August 4, 2025

Mike Badin
Black Sheep Construction, LLC
350 Raleigh Street
Holly Springs, North Carolina 27540

I have reviewed the Badin residence plan being constructed at 164 Horse Path Lane in Holly Springs, North Carolina as well as the pictures you have provided to address two framing issues. The original plan was designed by Triangle Residential Designs Inc. and the engineering was sealed on October 9, 2024. All new construction shall conform to the 2018 North Carolina Residential Code (2018 NCRC), plus all local codes and regulations. All relative directions are noted as if one were facing the front elevation as noted on the architectural drawings. Analysis revealed the following:

FOUNDATION PLAN
S-1
SHEET 1 OF 4

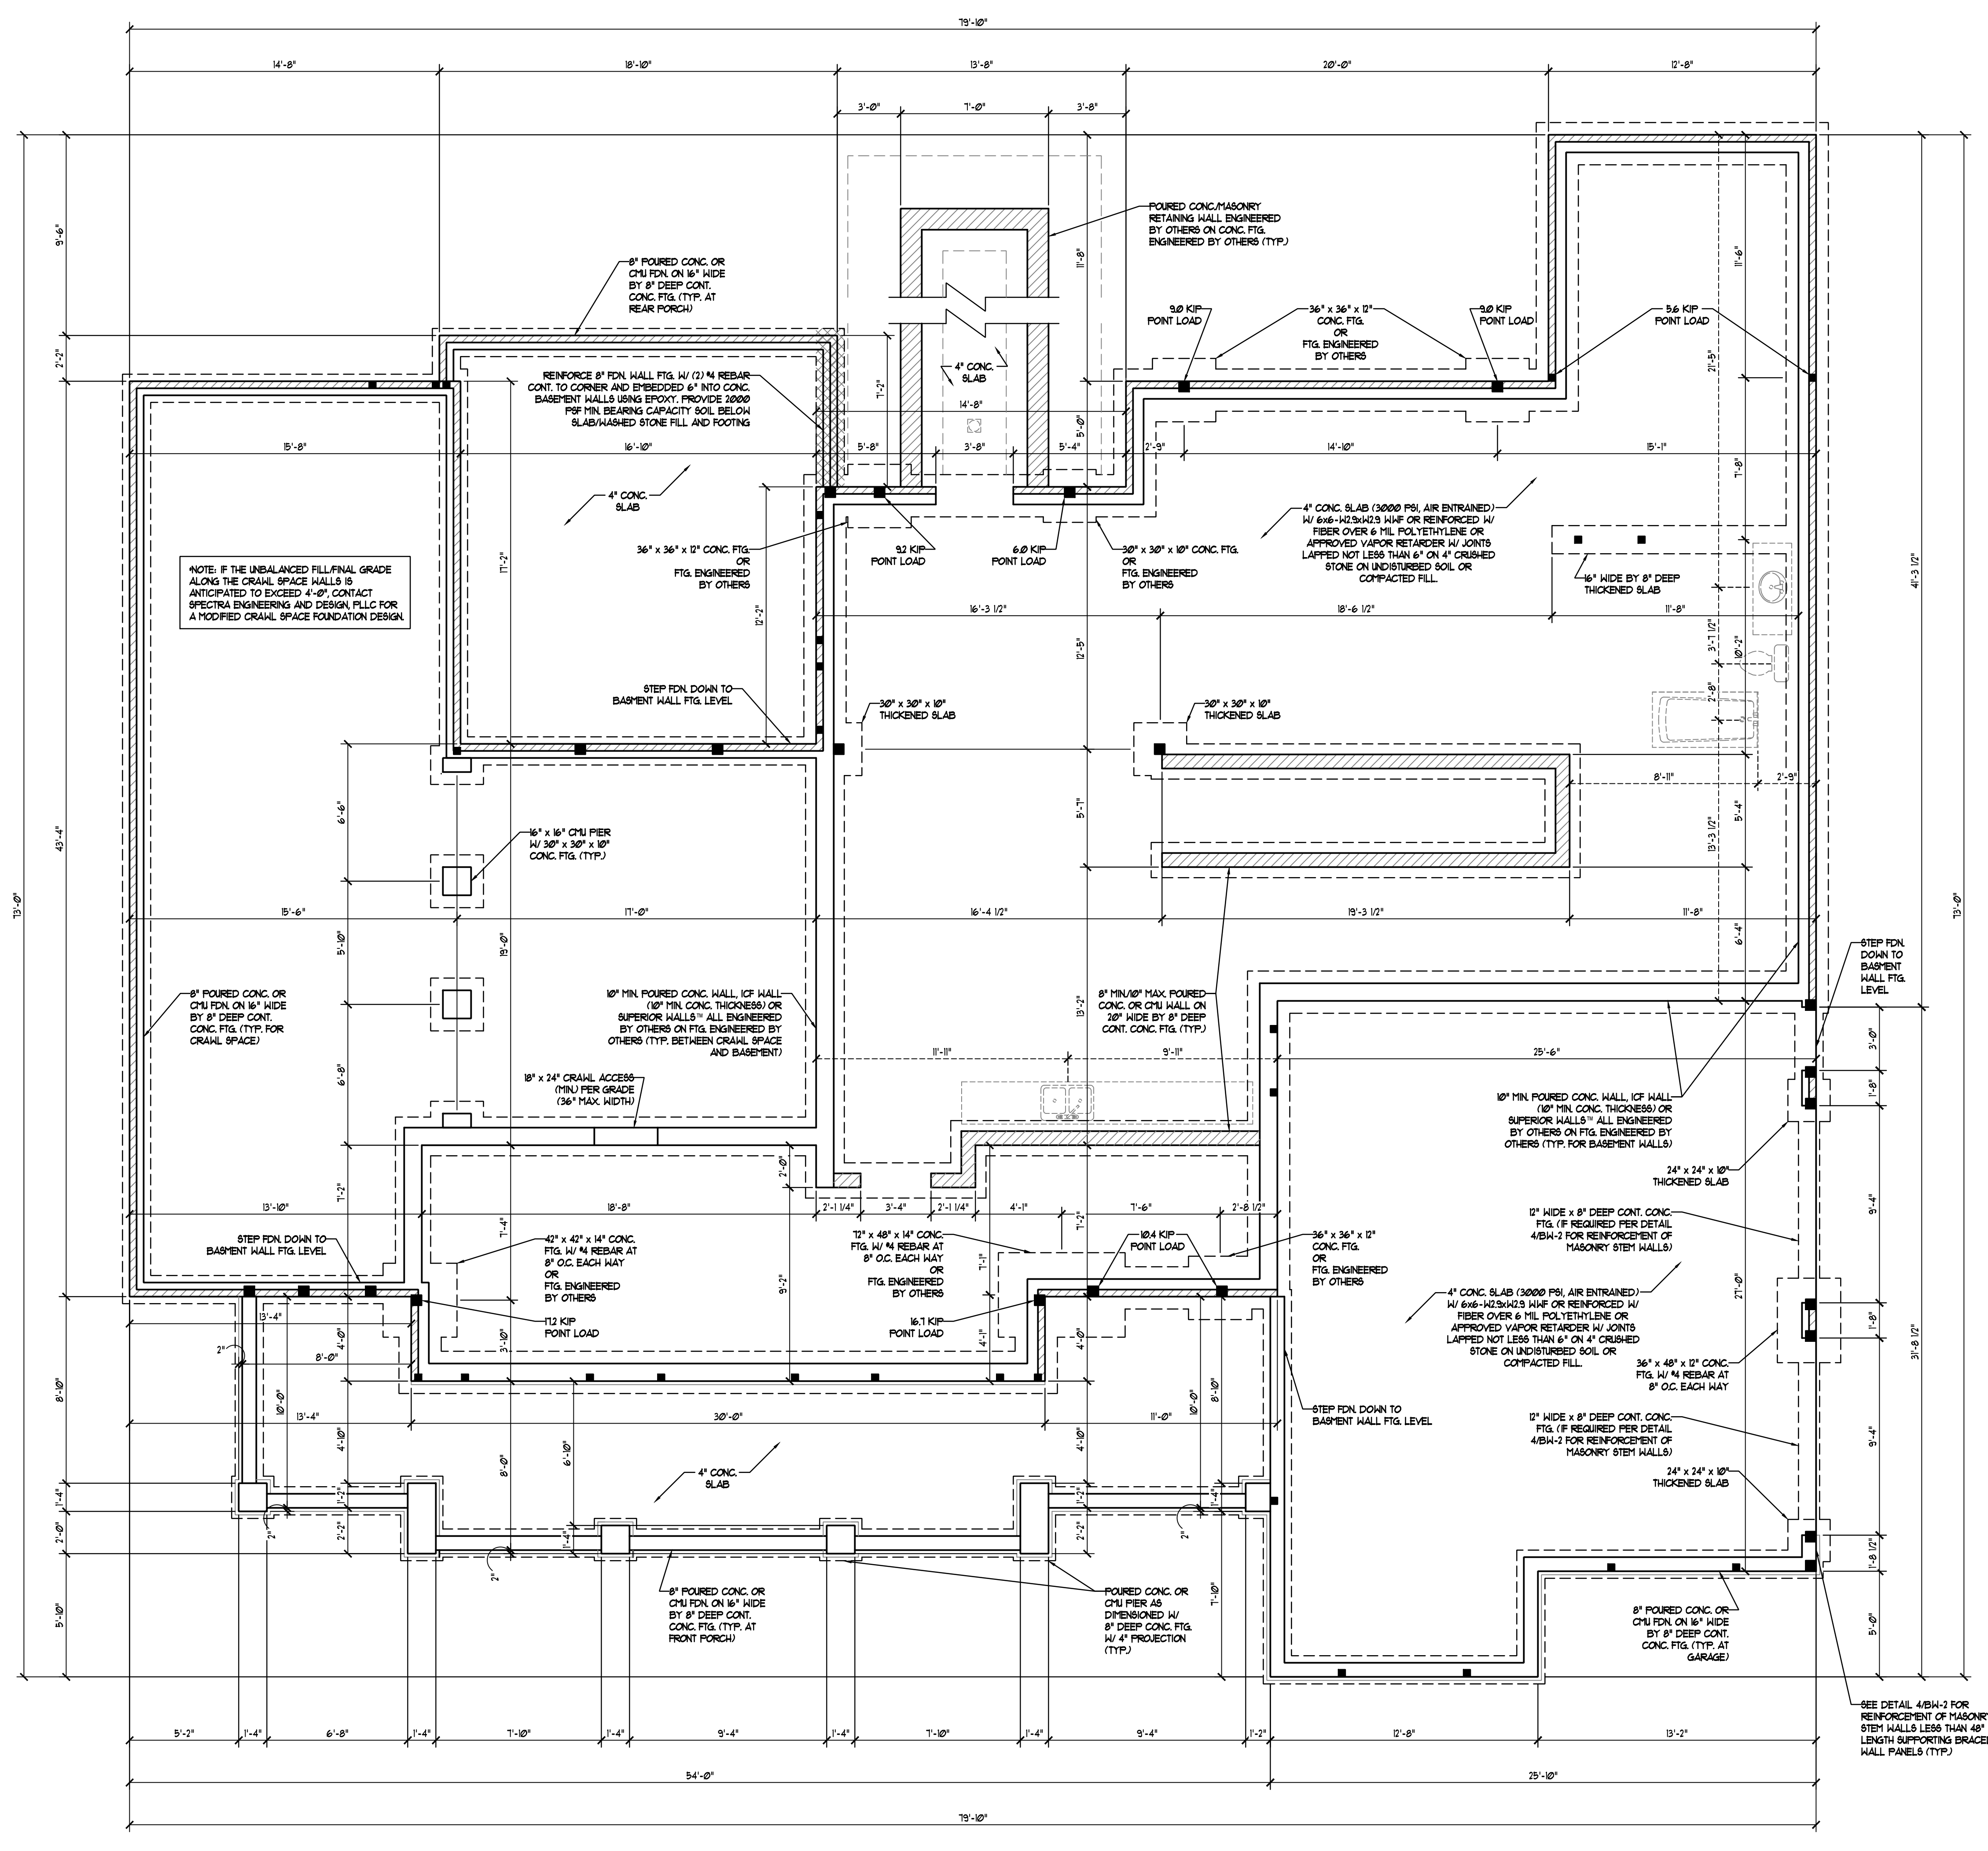
- 1) As per our conversation and the pictures, two W10 x 33 steel beams were installed in the basement directly below the first floor system. One beam is located below bedroom #3 spanning left-to-right approximately 11'-0" from the stairwell rear right corner to the basement right foundation wall. The other beam is located below bedroom #2 spanning left-to-right approximately 11'-0" from the basement foundation wall below the game room rear right corner to the basement right foundation wall. Each beam is supported by a 6 x 6 pressure treated post at each end with 2-ply 1 3/4" thick LVL pack-out material installed between the end of beam and the Superior Walls™ foundation wall at each end. The steel beams, LVL material, and supporting 6 x 6 posts may be considered to be supporting no loads other than self-weight with no additional modification required provided the first floor system is connected to the top of the Superior Walls™ foundation walls as per the requirements of the Builder Guideline Booklet™ provided by Superior Walls™.

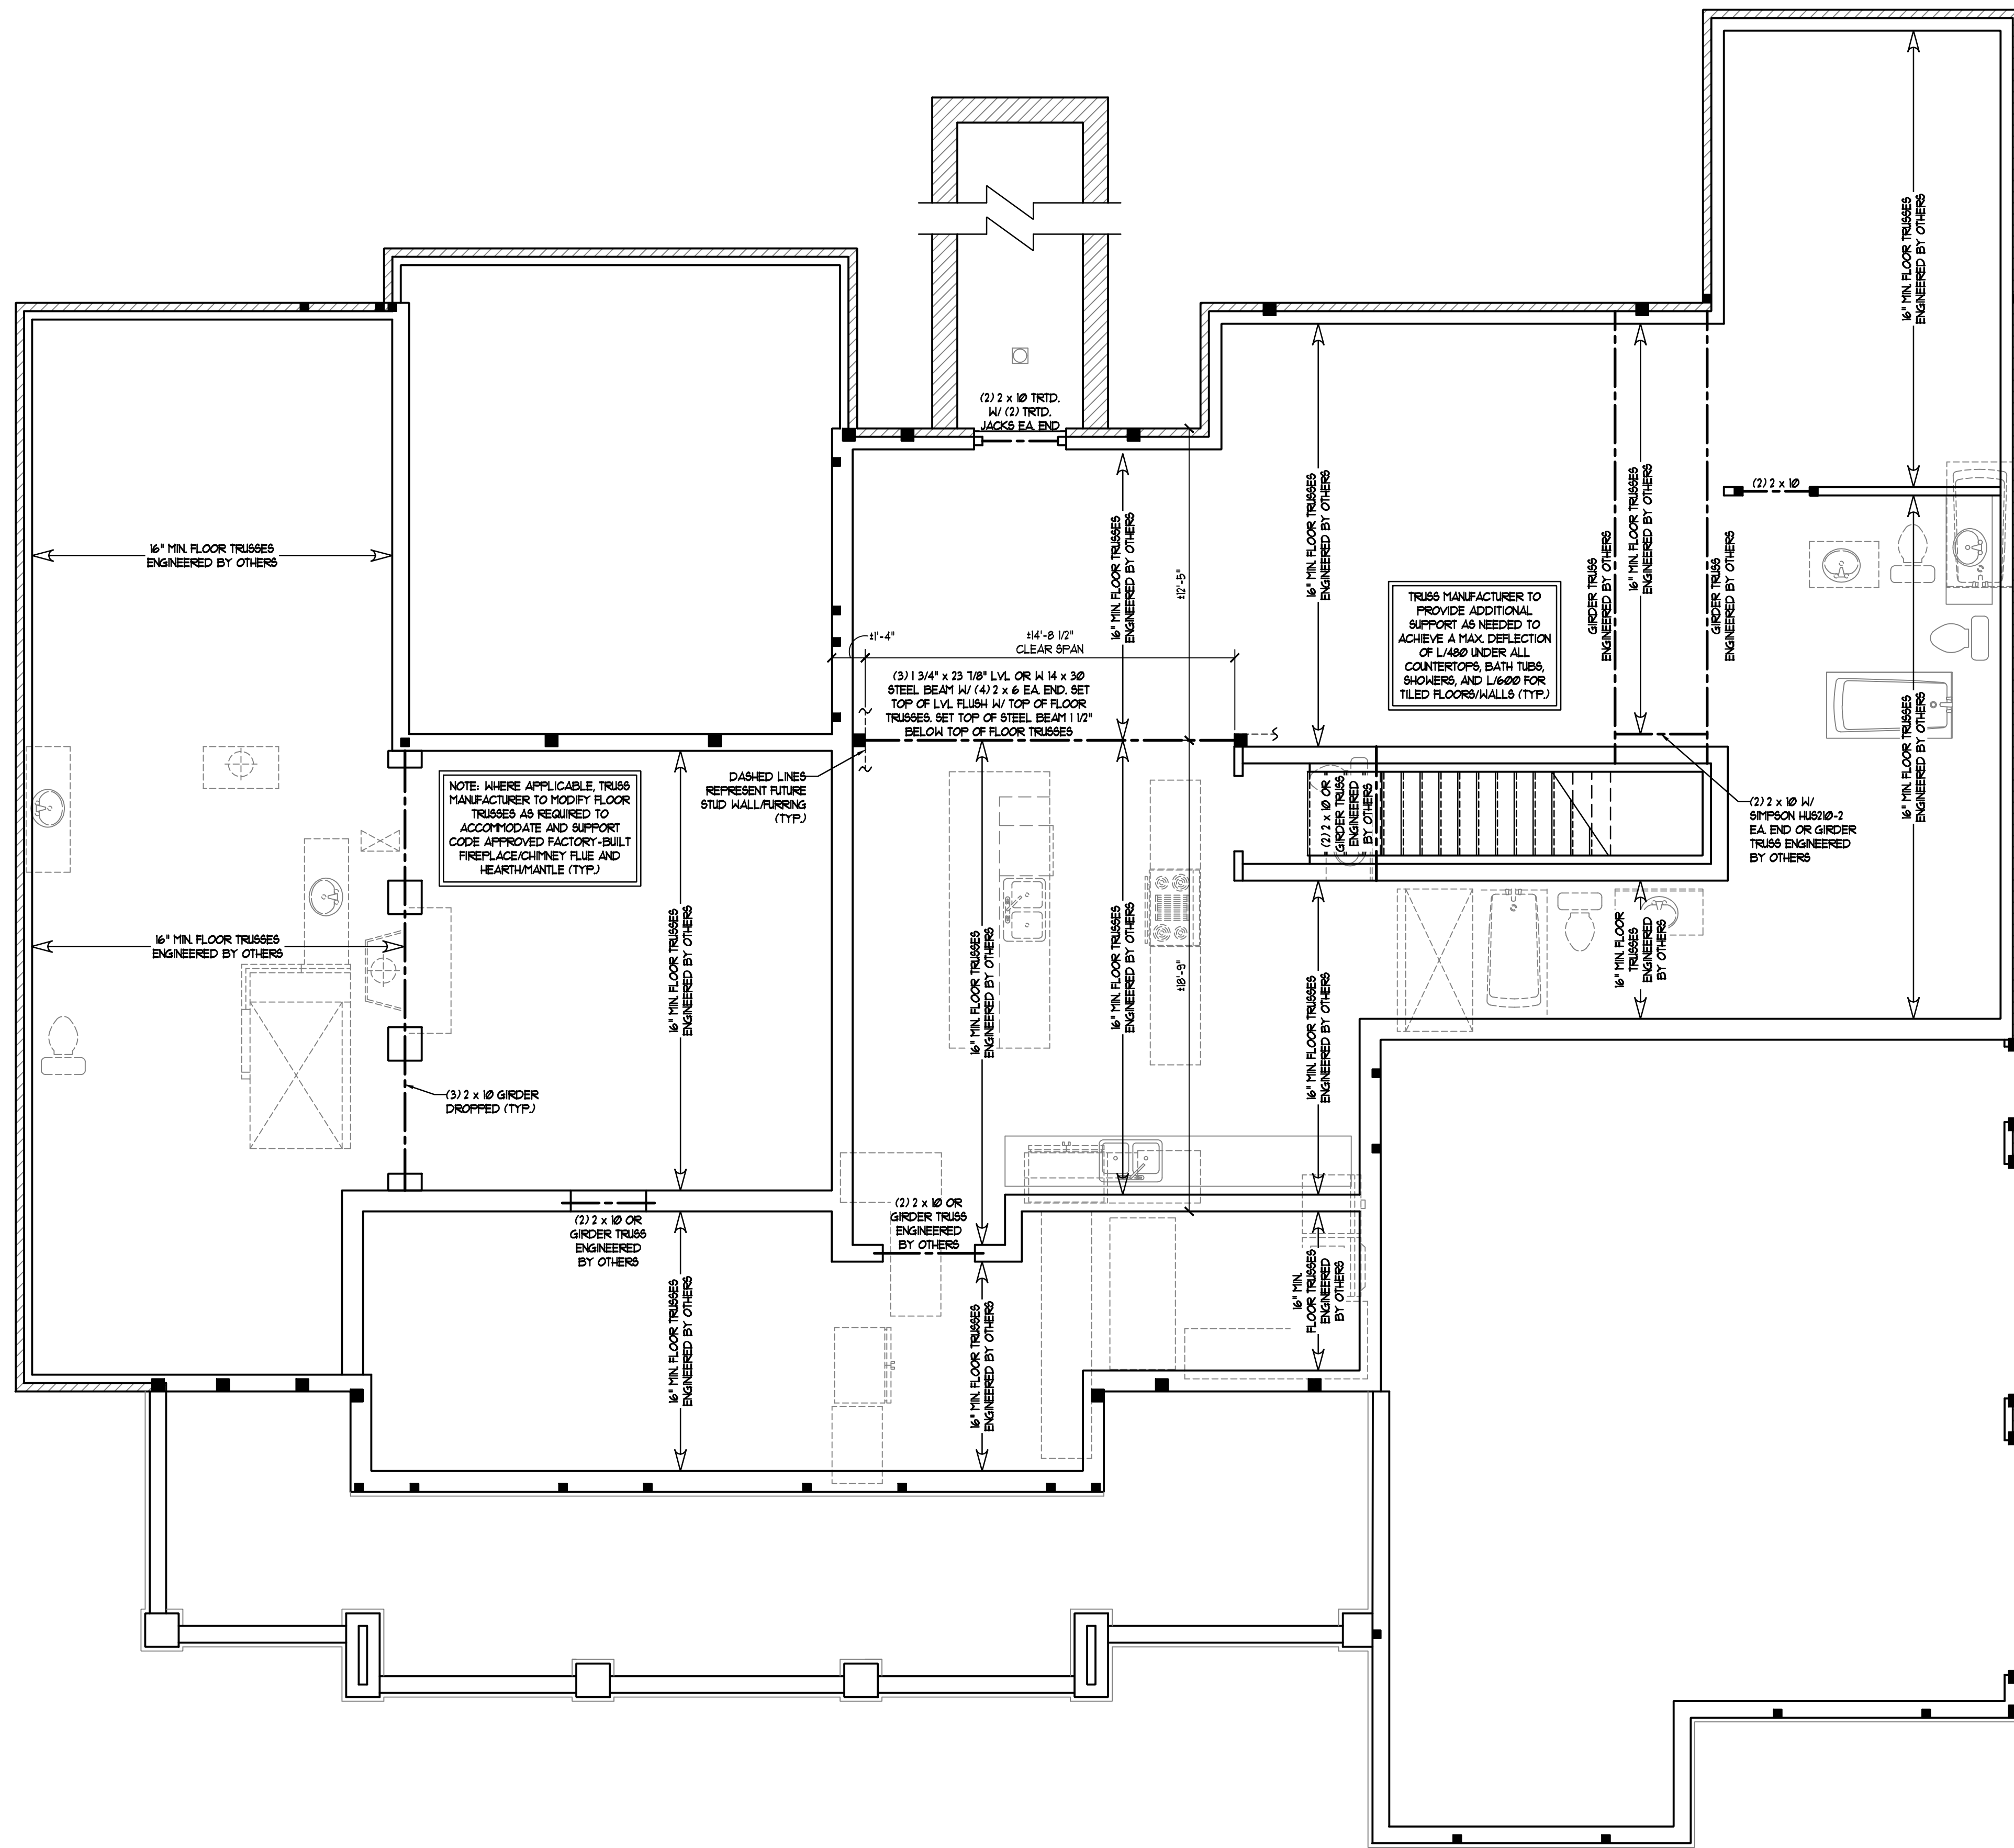
- 2) The two 9'-0" x 8'-0" garage door openings specified on the plan may be omitted and replaced with a single 18'-0" x 10'-0" garage door opening centered approximately 4'-5" back from the garage front right corner. The opening is to be framed with a (2) 1 3/4" x 23 7/8" LVL installed continuously from corner to corner along the garage right wall with five 2 x 6 jacks at each end of the opening. Install two Simpson CS16 coiled straps on the inside face of each 2 x 6 jack column lapped 15" minimum onto two

of the jacks in each column and 15" minimum onto the inside face of the LVL header (the header may be packed out as needed for the strap installation). Construct the wall segment at the front end of the opening as required for an approximately 4'-5" long CS-PF braced wall panel. Additionally, verify a 30" x 30" x 10" deep minimum concrete footing centered below each end of the opening.
